DEVELOPMENT HEARING OFFICER

Planning Comments

Project Number: PR-2022-007589

Project Name: Parcels B-1 and C-1-A, Tijeras Place Addition

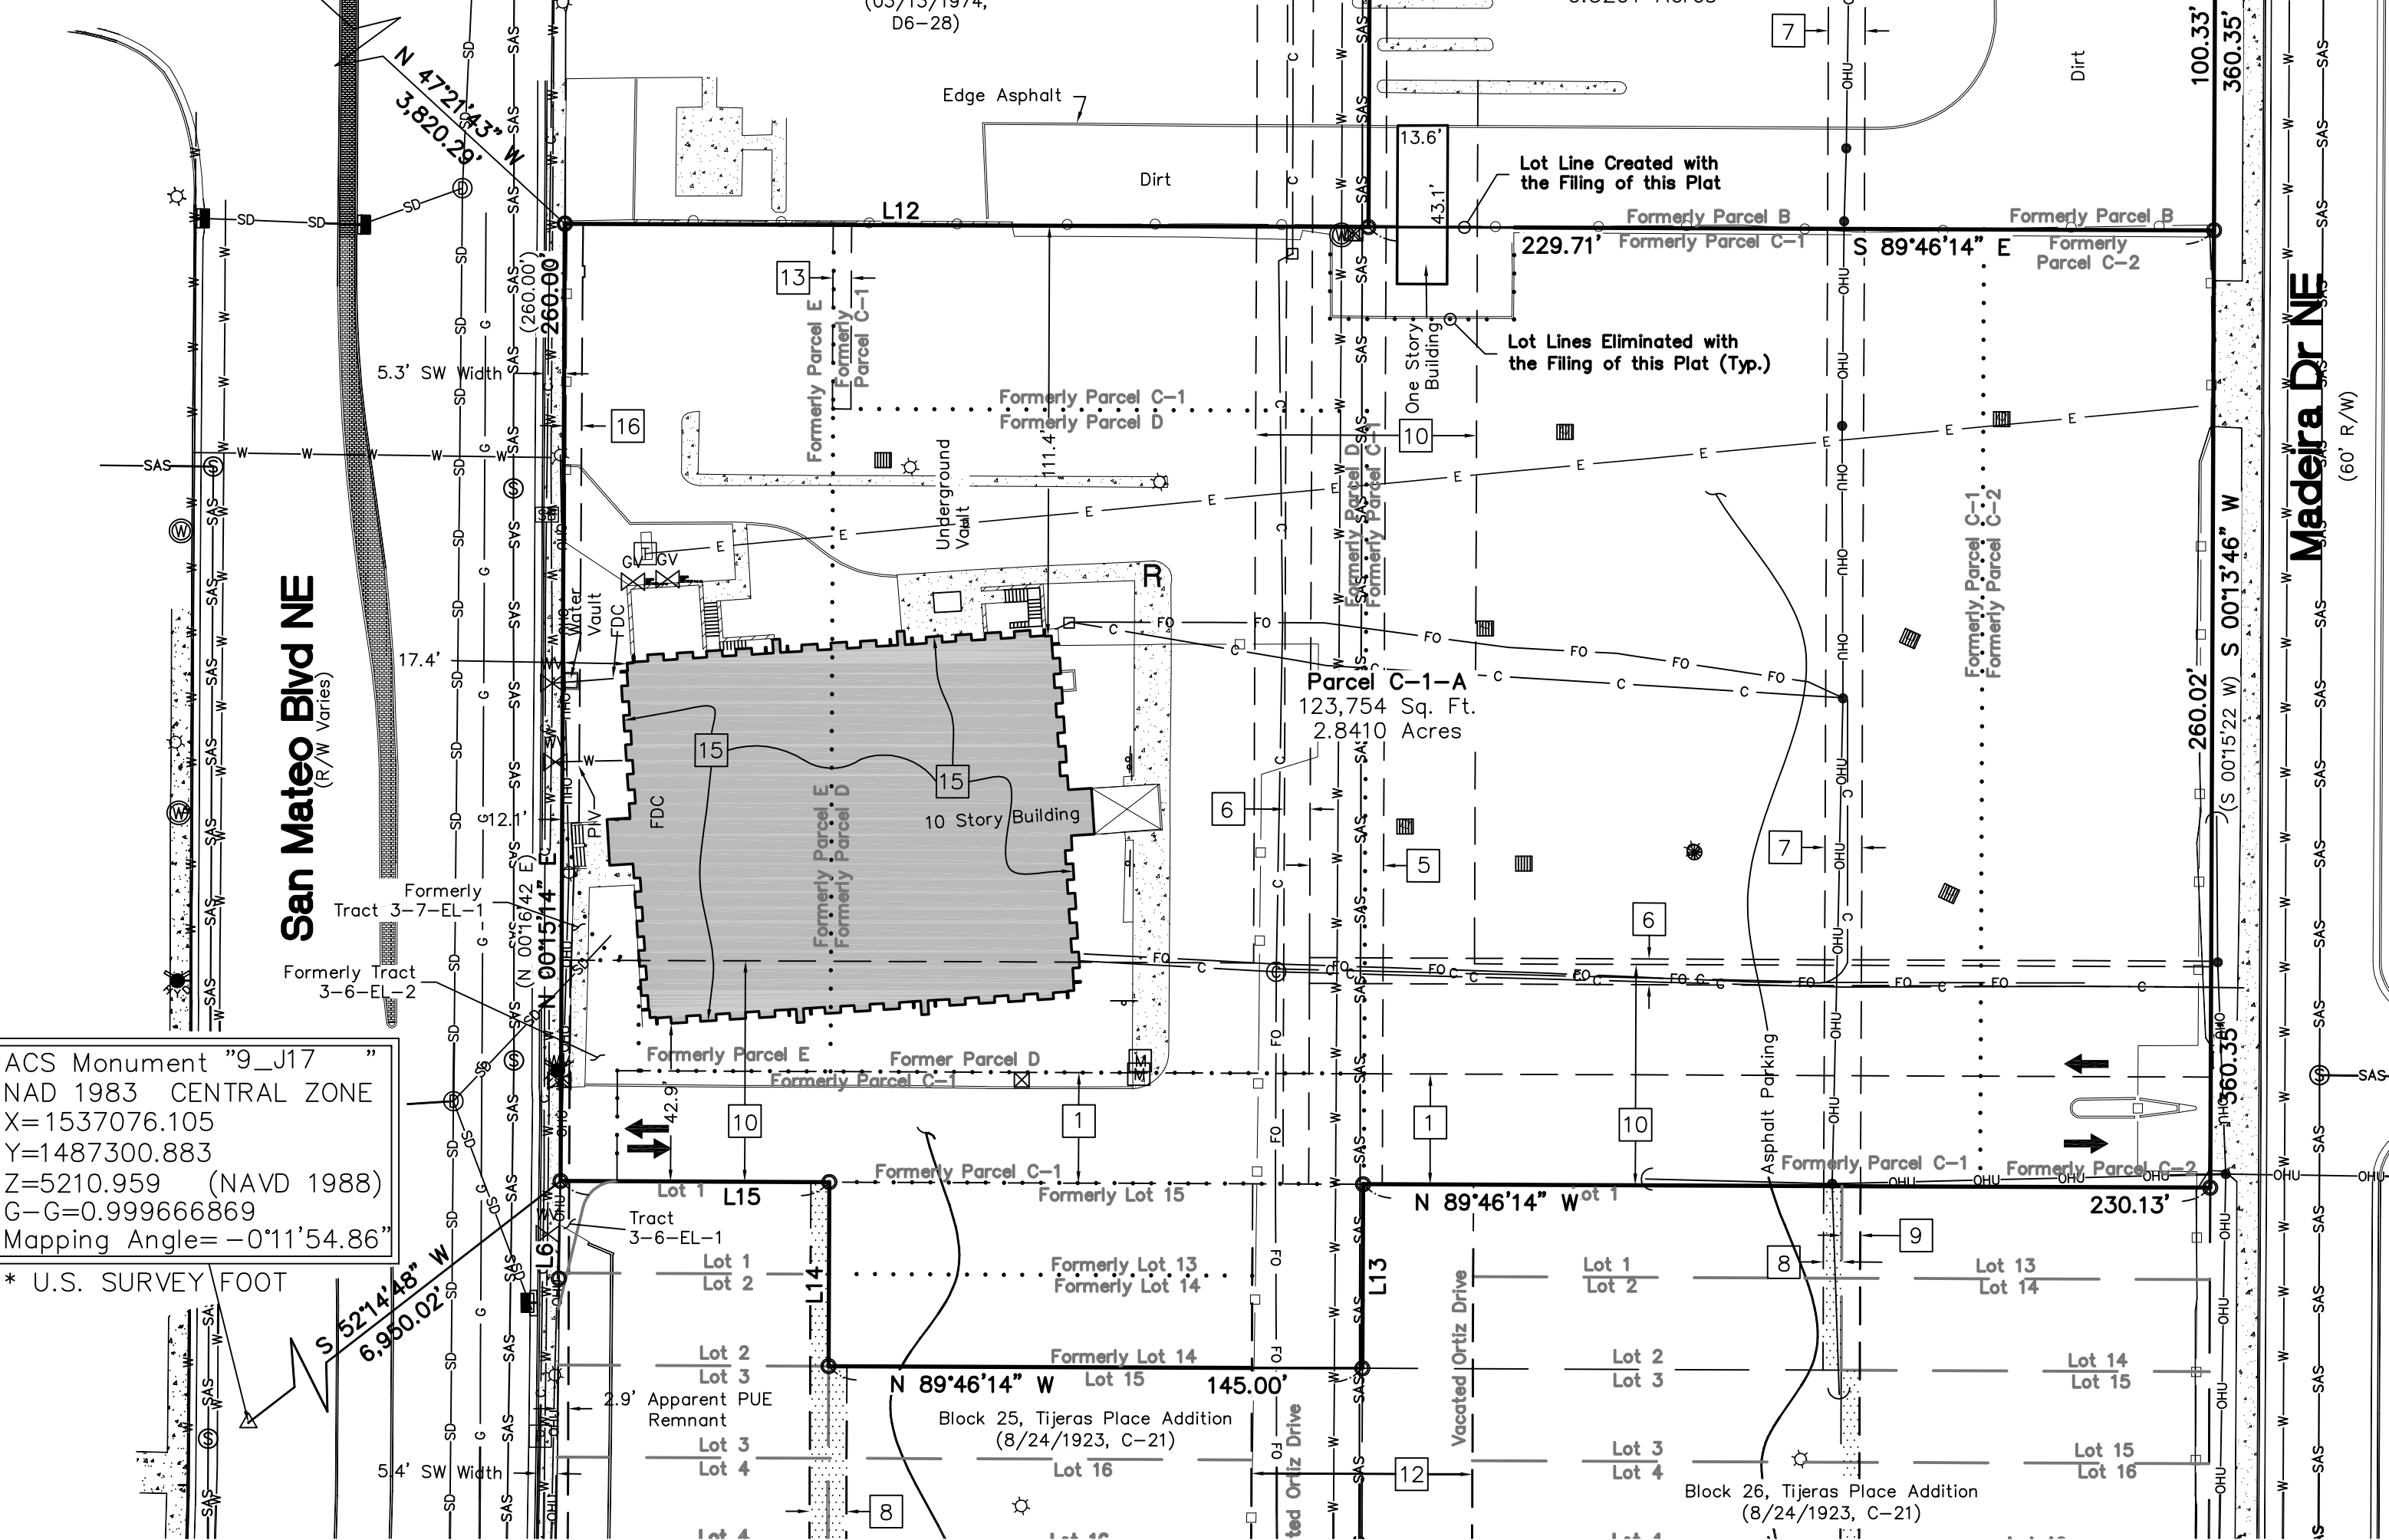
- This replat proposal proposes the consolidation of nine (9) existing lots/parcels into two (2) lots/parcels (Parcel C-1-A and Parcel B-1).
- There are two zone districts present on the subject property, MX-L and MX-M. The Plat depicts Parcel B-1 (which is zoned MX-L) as delineated from the remainder of the site which is zoned MX-M. Therefore, a Zone Map Amendment will not be necessary as a result of the proposed replat.

- Parcel C-2 (101805704926232230) is shown in Bernalillo County Property records as being owned by GGD Oakdale LLC, while the remainder of the parcels comprising the subject property are owned by Rhino Holdings Tower 10 LLC. GGC Oakdale LLC must sign the Plat as an owner of one of the parcels on the subject property.

A3 DRB SITE PLAN  
1" = 50'-0"

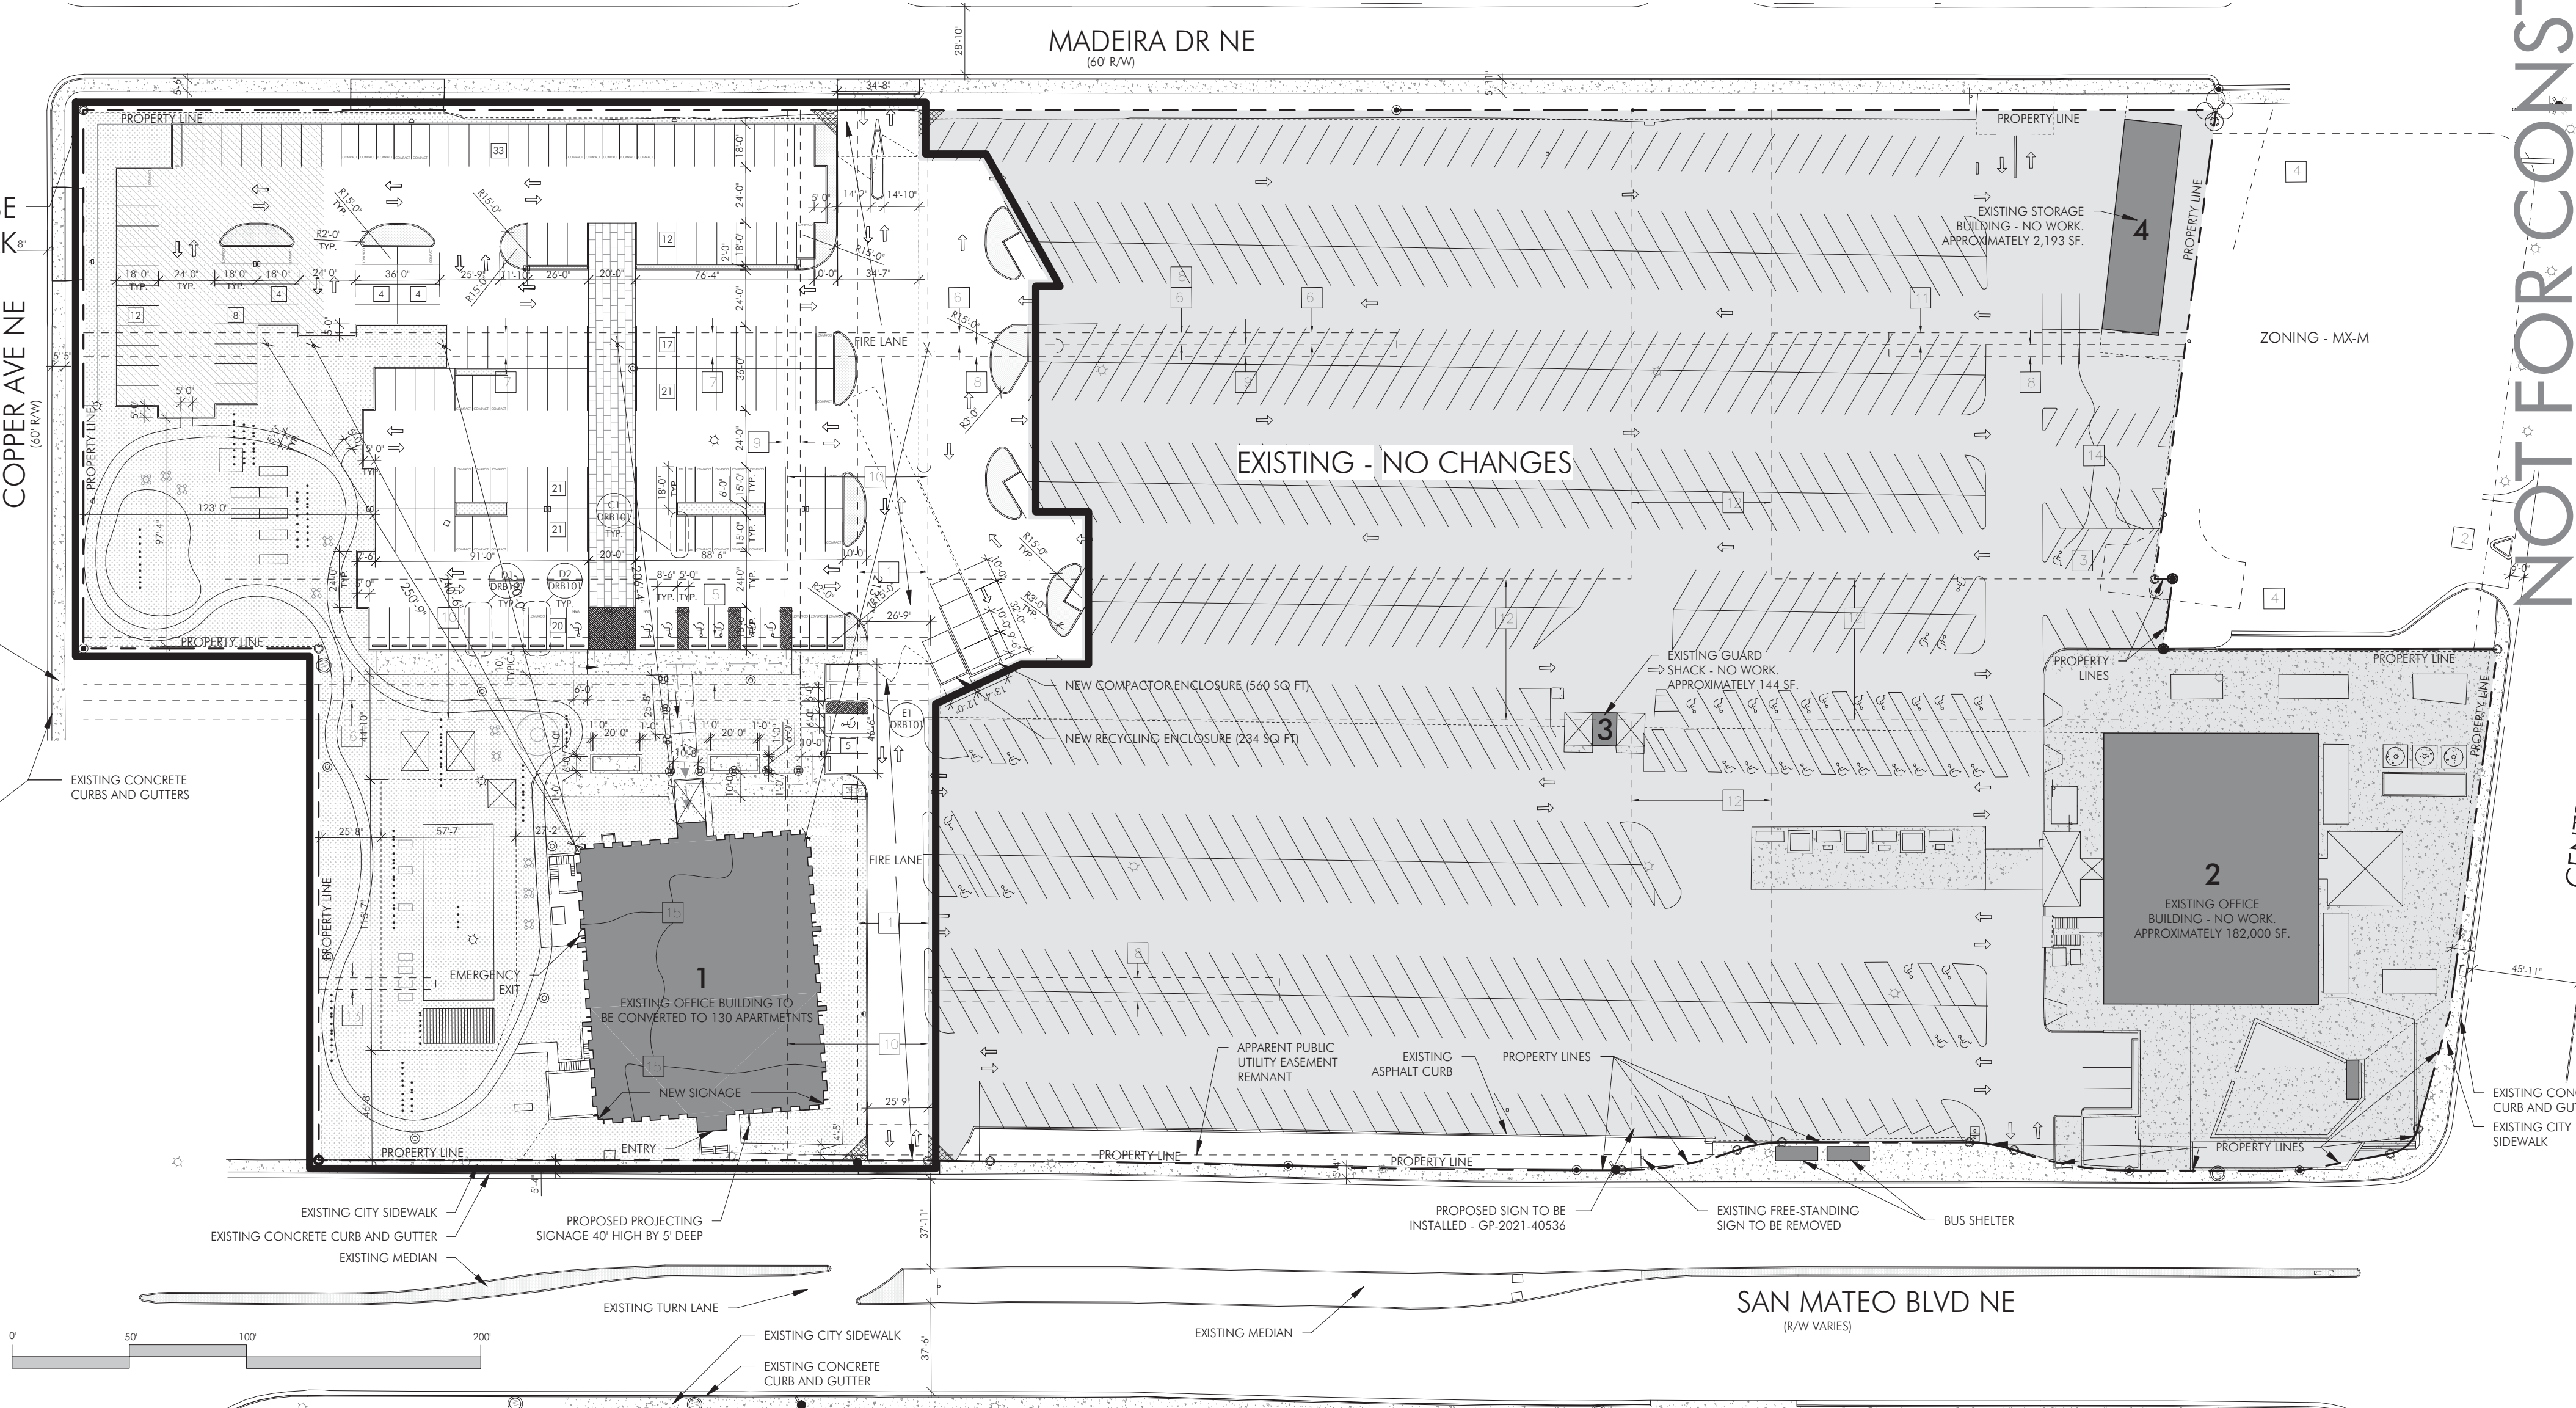
- The application submittal details how the existing principal building on proposed Parcel C-1-A on the subject property will be retained for residential use, and how the proposed Parcel B-1 will have amenities for the residences such as a path around playground and a community garden with the remainder consisting of parking. The application submittal also mentions the existing accessory building straddling between Parcel B-1 and Parcel C-1-A, but doesn't elaborate on whether the building will be retained or removed. This building cannot straddle on top of both lot lines.

- A multi-family residential use is proposed on the subject property. Clarification must be provided that the parking requirements of Table 5-5-1 of the IDO are being met for the proposed use, as well as how those requirements are being met. A large parking lot is abutting along the southern boundary of the subject property (owned by Rhino Holdings Tower 17 LLC). Is that parking area required to be utilized for the proposed development on the subject property, and if so, there any shared parking agreements permitting access to the parking area to the south?
